**From:** [Downes, Scott G \(DFW\)](#)  
**To:** [Jeremiah Cromie](#)  
**Cc:** [Torrey, Elizabeth M \(DFW\)](#)  
**Subject:** RE: RU-22-00004 Marlatt - Notice of Application WDFW Comments  
**Date:** Monday, November 28, 2022 9:51:35 AM

**Subject:** RU-22-00004 Marlatt - Notice of Application

CDS is requesting comments on the following Reasonable Use application: **RU-22-00004 Marlatt**.  
Links to the file materials can be found below. The comment period will end on **Monday December 12, 2022 at 5pm (PST)**. CDS will assume your agency does not wish to provide comment if not received by this date. Please let me know if you have any issues accessing the materials.

Figure 2. Wetland map of the study area.

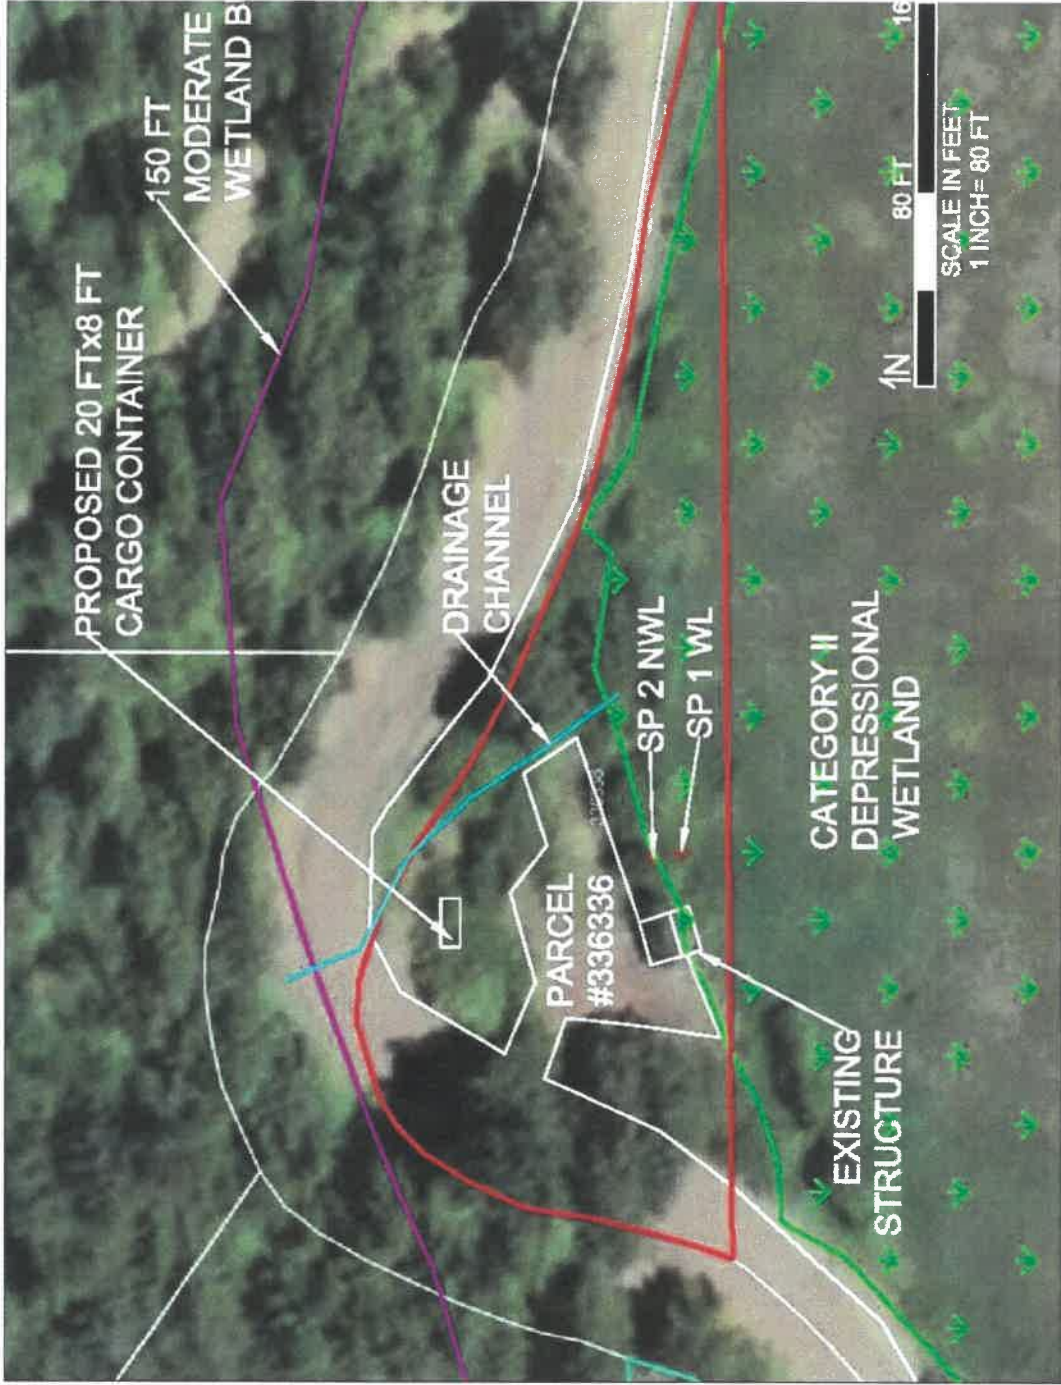
Thanks for sending. My follow-up question is has any agency been out to verify the proposed stream typing in the report? Yes, they are correct on an Ns needing surface connection, but we'd want to verify that this is an Ns as Np doesn't need surface connection and if it an Ns we'd want to verify that there is a lack of surface connection. If this has happened (agency has reviewed), then they should submit a Water Type Modification to remove this stream. If it hasn't, then WDFW or another agency needs to review the stream.

In addition to the wetland and associated buffer, there is a mapped Type N near where the cabin was placed and where the proposed cargo container is to be placed. WDFW would like to have a site visit to assess the stream, its location and the placement of the cargo container and cabin in relation to the stream. The discussion should also include potential mitigation if either are within the riparian zone for the Type N stream.

We can arrange a site visit if needed. They did address the stream channel (type N) in the report on page 4 saying it didn't qualify as a Type Ns as it does not connect to a higher order water by an above ground channel per [KCC 17A.04.020 \(4\)\(d\)](#) . Let me know if this changes any comments you may have. For reference, I have attached Grette's report.
